**SSD-31552370 EXHIBITION OF ENVIRONMENTAL IMPACT STATEMENT
WAREHOUSE DEVELOPMENT – 42 RAYMOND AVENUE, MATRAVILLE**

Thank you for referring the exhibition of the Environmental Impact Statement (EIS) associated with the above proposed warehouse development (SSD-31552370) to Transport for NSW (TfNSW) for review and comment. The agency has reviewed the EIS and request's that the Applicant addresses the below matters as part of the Response to Submissions (RtS):

Figure 10: Key Intersections

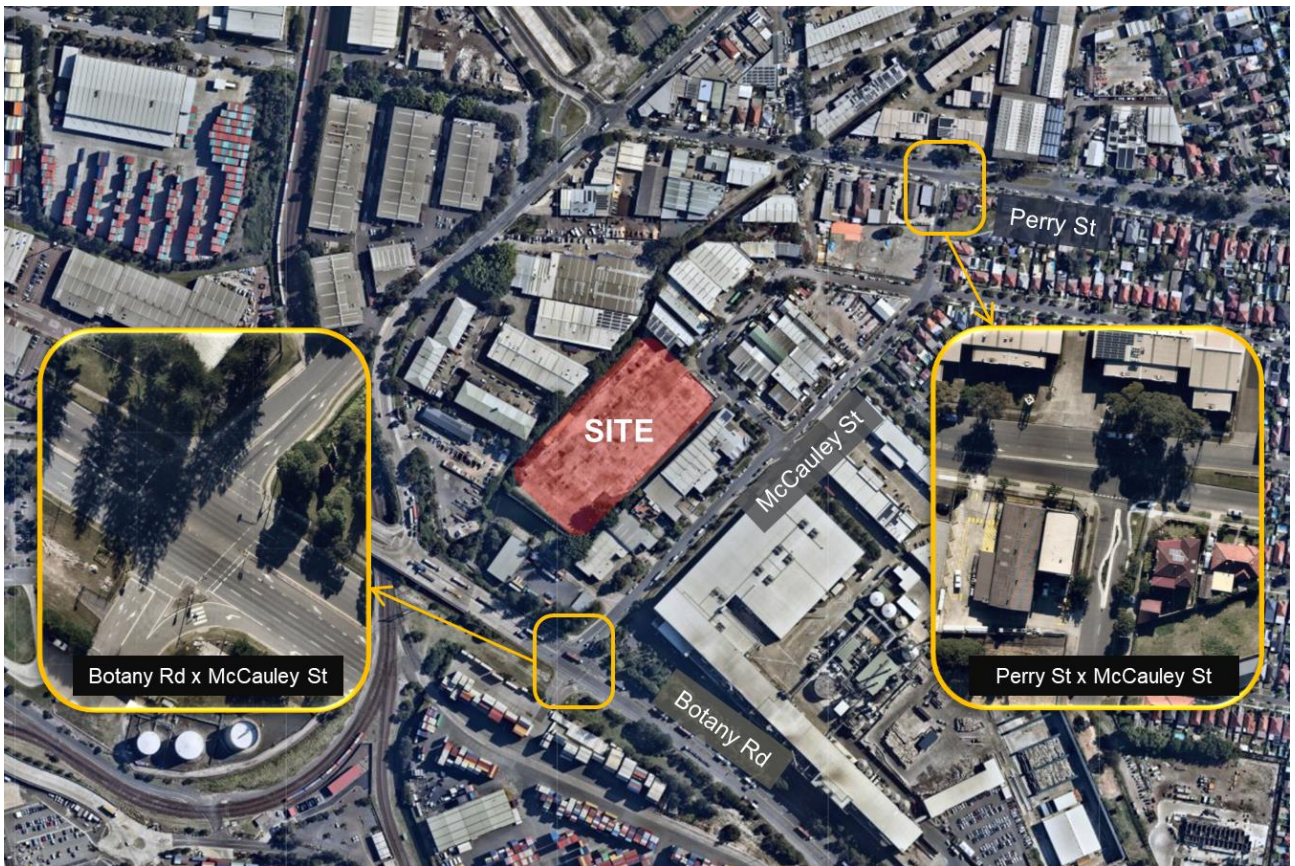
Impact to the existing Botany Road and McCauley Street signalised intersection:

The signalised intersection of Botany Road /McCauley Street is a major intersection used by high volumes of traffic where network safety and efficiency are of great importance.

3. The annual growth rate from 2021 to 2031 (based on TfNSW Sydney Strategic Model) is 2.2% and 1.7% for the AM and PM peak periods respectively.
4. The setup parameters in the base model are not in accordance with the SCATS data, for example the cycle length should be 130 seconds. Individual phase times should be optimised for the base and future scenario comparisons. The Applicant can obtain further information regarding key input parameters via email scats.traffic.signal.data@transport.nsw.gov.au

5. It is noted that the intersection models are using default settings. The following modelling inputs should be addressed:

- a) actual grades should be used
- b) pedestrian walk and clearance times are too short
- c) pedestrian volumes are shown as 1 person
- d) Consideration of Peak Flow Factors
- e) truck speeds to be reduced to a more appropriate value
- f) late starts missing on A, B and C phase
- g) Amber time is 5 seconds and Red time 3 seconds for D phase

The Applicant is to address the above matters as part of the RtS including appropriate mitigation measures to the satisfaction of the agency.
